RE: Timber Clad structure at Harefield Hospital - Ref: 9011/APP/2018/1854

Retention of hospital waste store (Retrospective Application) with new boundary hedge planting.

N West Elevation as Proposed
PL-003 SCALE: 1:50 @ A1

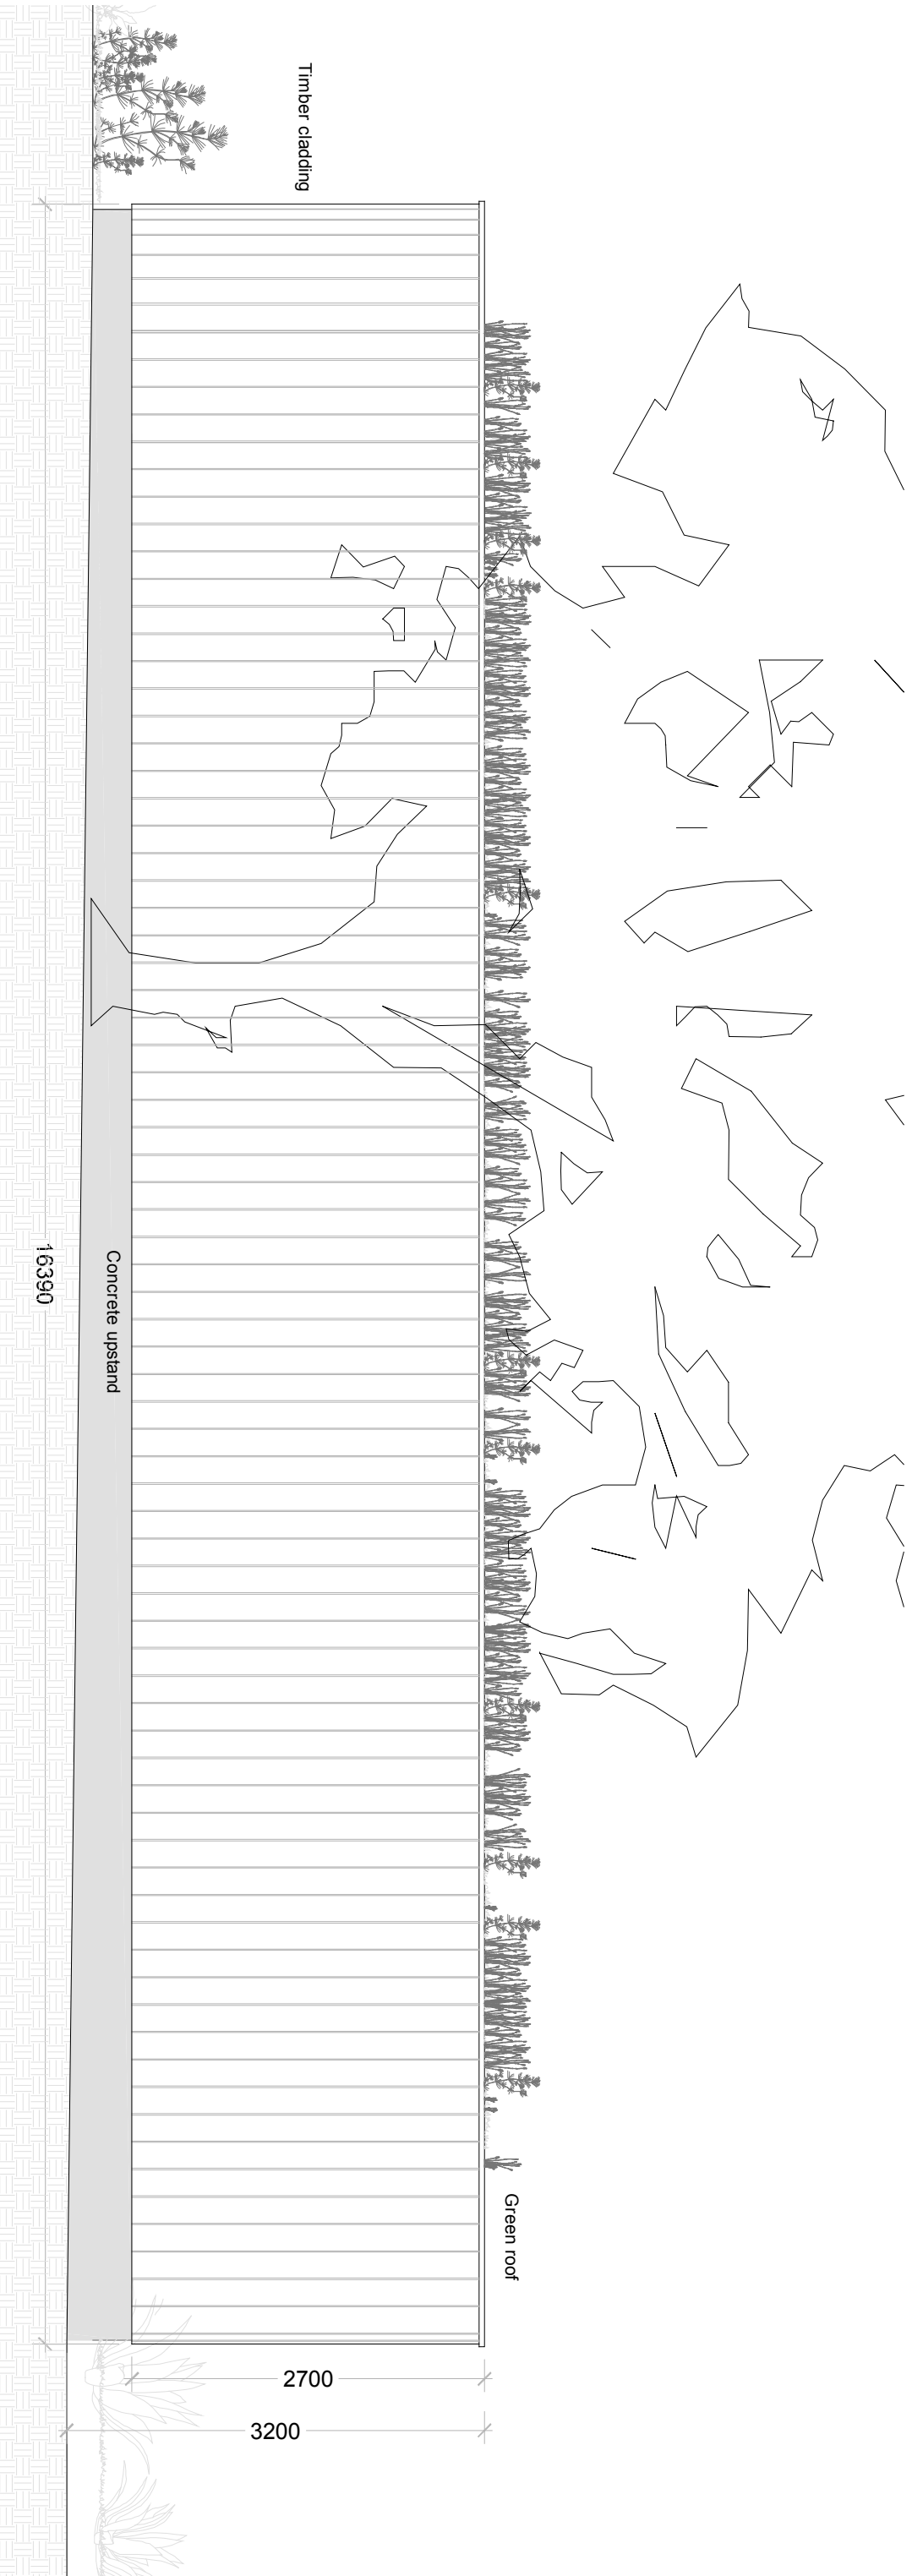
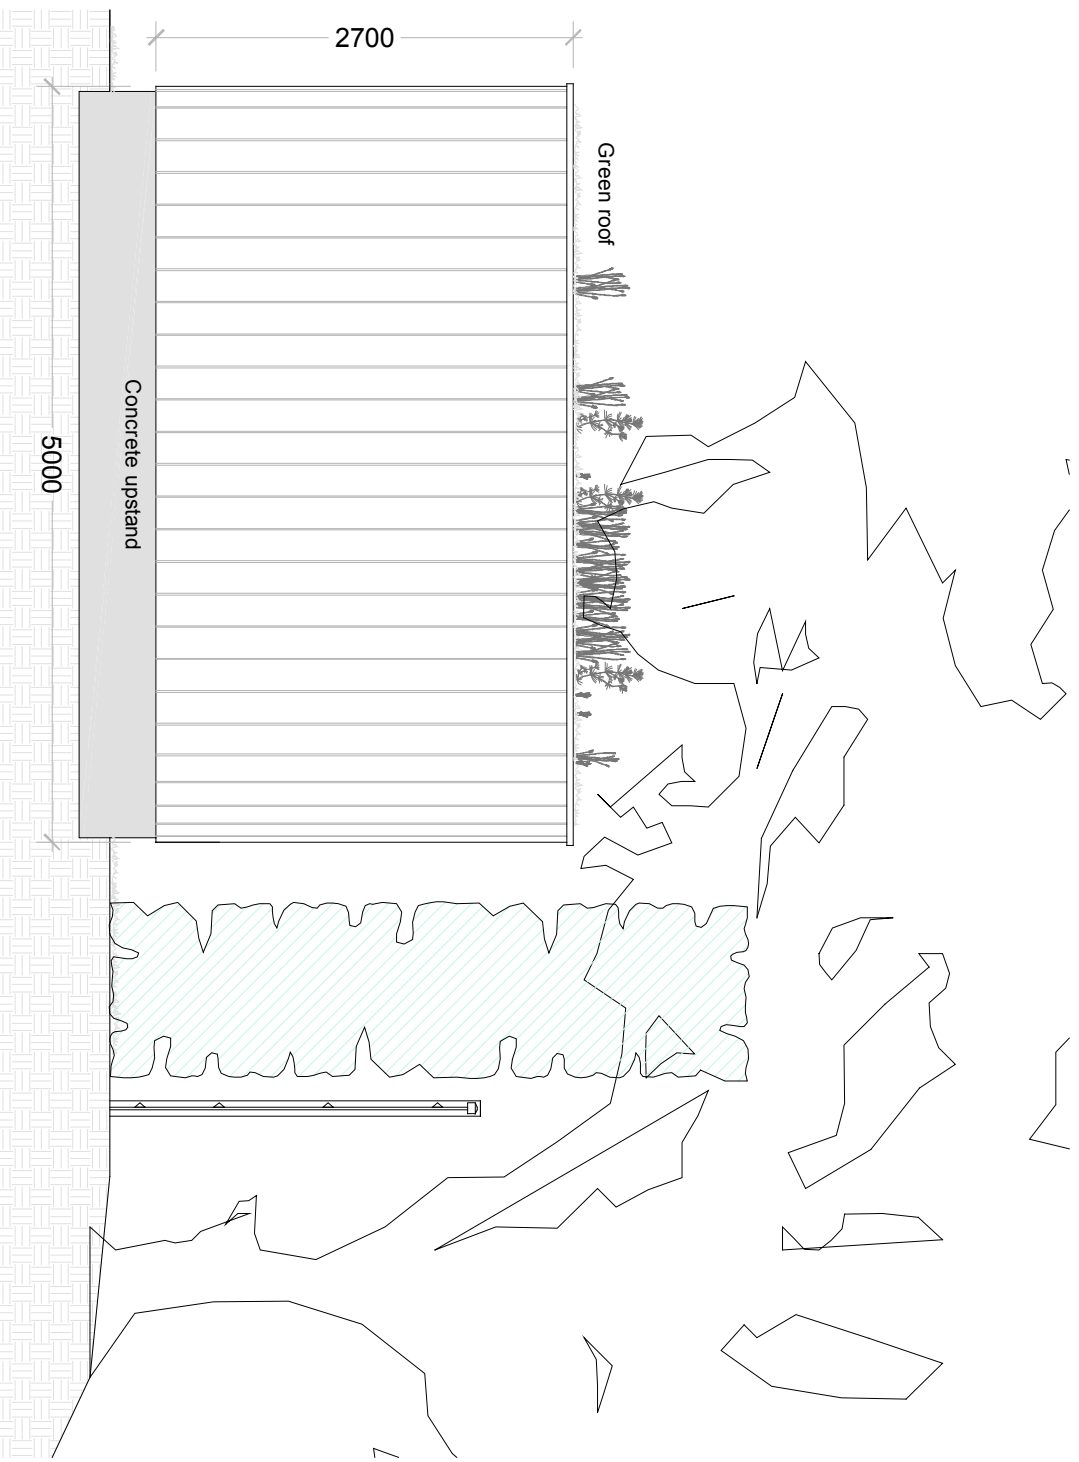
There is a side fence shown at the square end of the store on the floor/elevation plan which is not shown on the site plan, (described as 'Location Plan' - Drw. No. PL-002 refers) - can this be added - it will make things a little clearer.

With respect to the dimensions of the structure, it is considered that the bin store as erected on site exceeds the dimensions of the bin store submitted to the Council under 9011/APP/2015/3508. To this end, the West Elevation height measurement on approved plan stated 2.850m. This was measured at approx 3.2m this morning. There was other minor variations on the height of the structure. The length of the structure on previously approved plans was shown at 14.660m. This was measured on site at approx. 16.35m. The width of the structure as previously approved was 4.2m and this was measured on site at
